KRP/AJK/45245-001

12 August 2020

Chambers Road, Platts Common Coal Mining Risk Assessment

SITE PLAN
 SCALE 1:500 AT A3

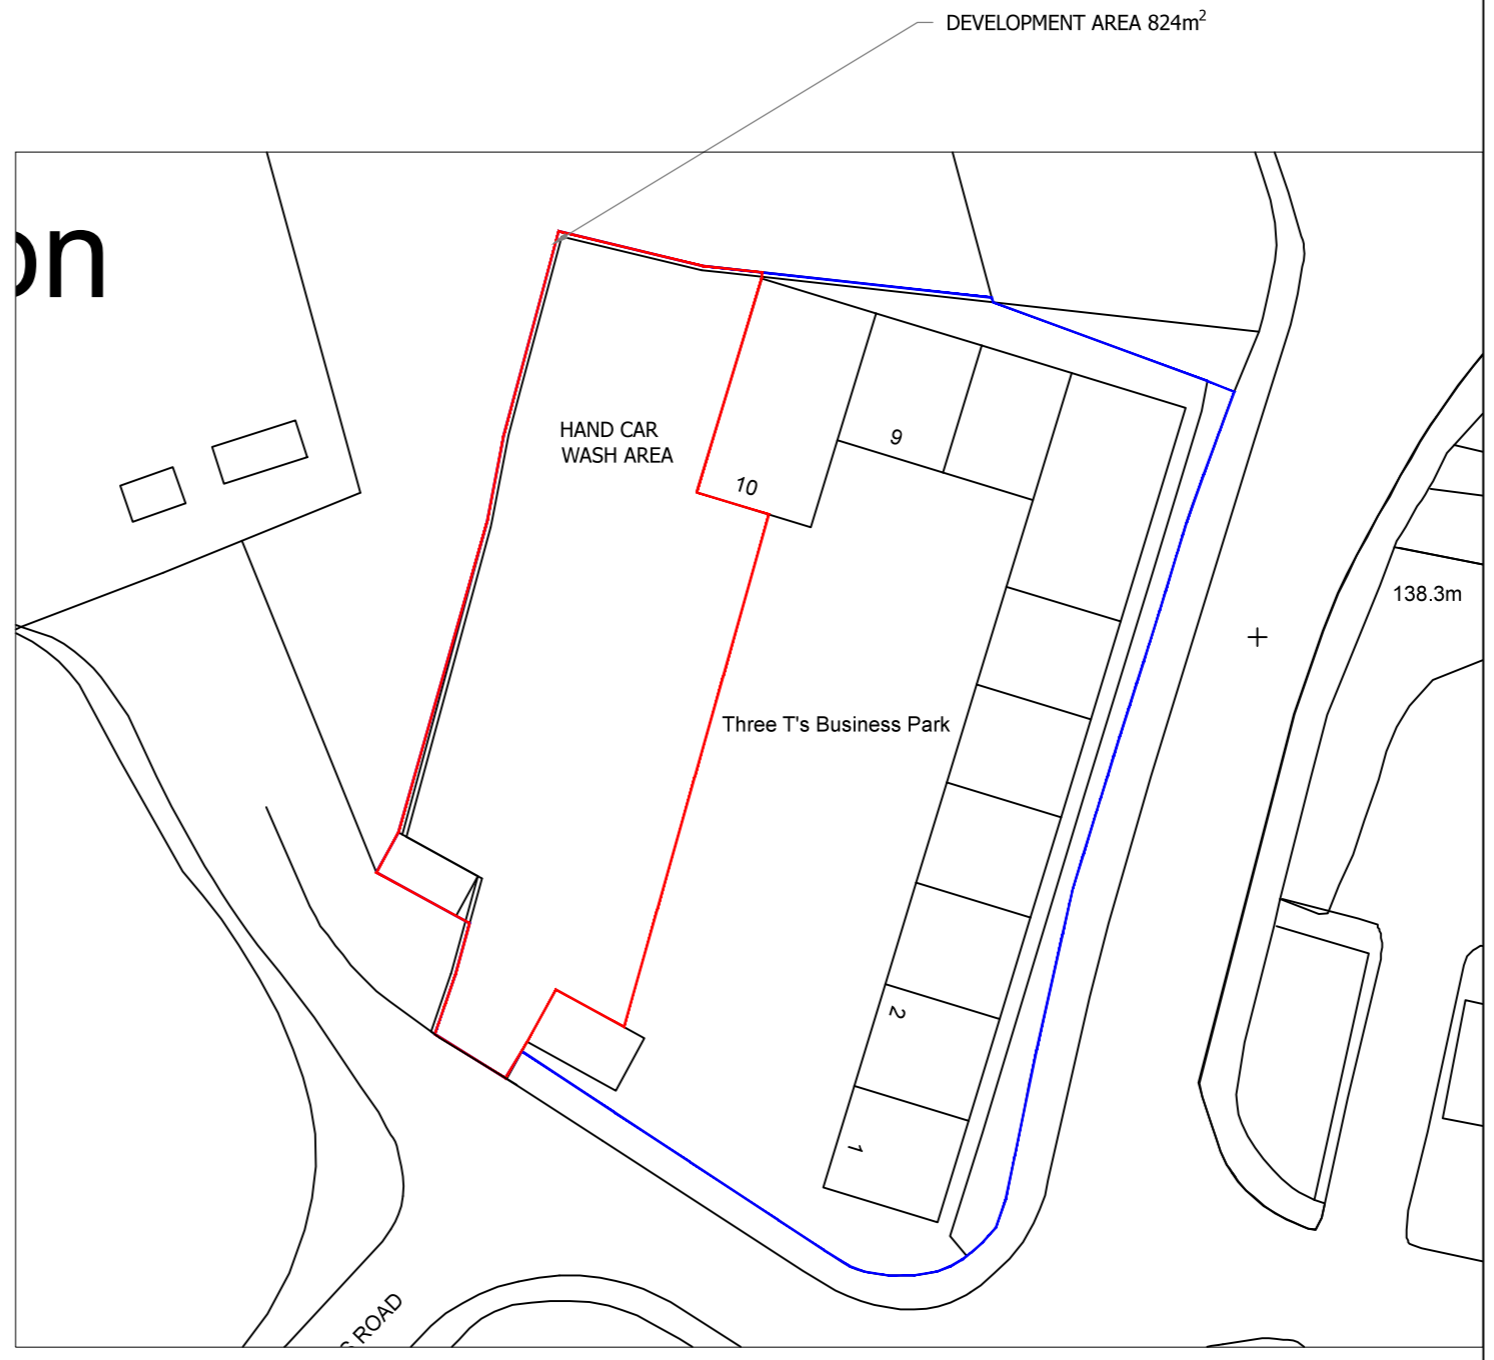
It is noted from the proposed layout (copy attached) that the buildings are positioned to the east of the indicated shaft position. However, depending on the amount of made ground present, it is possible that piled foundations could be required to transfer foundation loads to the bedrock. Car parking is shown over the shaft, and this may need to be relocated, depending on the shaft cap construction and whether this can be proven to be satisfactory to accept direct vehicle loadings.

The proposed development will need to avoid placing buildings over any of the shafts or their caps, and should ensure that no foundation loads are transferred to the shaft cap or edges of the shaft itself. It will be necessary to investigate the actual location of the shafts to determine if they are present on site or not, and to determine the depth to competent ground to allow a suitable foundation to be designed.

However, there is at least one mine shaft expected within the site boundary, and this will need to be accurately locate dot ensure that it does not underlie the proposed buildings. The mine shaft cap should also be investigated to determine its thickness and size, and to confirm if it has been constructed on competent ground. A trial pit investigation is considered appropriate for this. It would also be prudent to undertake trial pits targeting the points of the site nearest to the other recorded shafts to confirm that these do not encroach onto the site.

The proposed building will need to be founded on competent bedrock in order to prevent any foundation loads being transferred to the nearest shaft. This may mean that piled foundations are required if the depth to bedrock is significant. The trial pit investigation will need to confirm the depth to the bedrock.
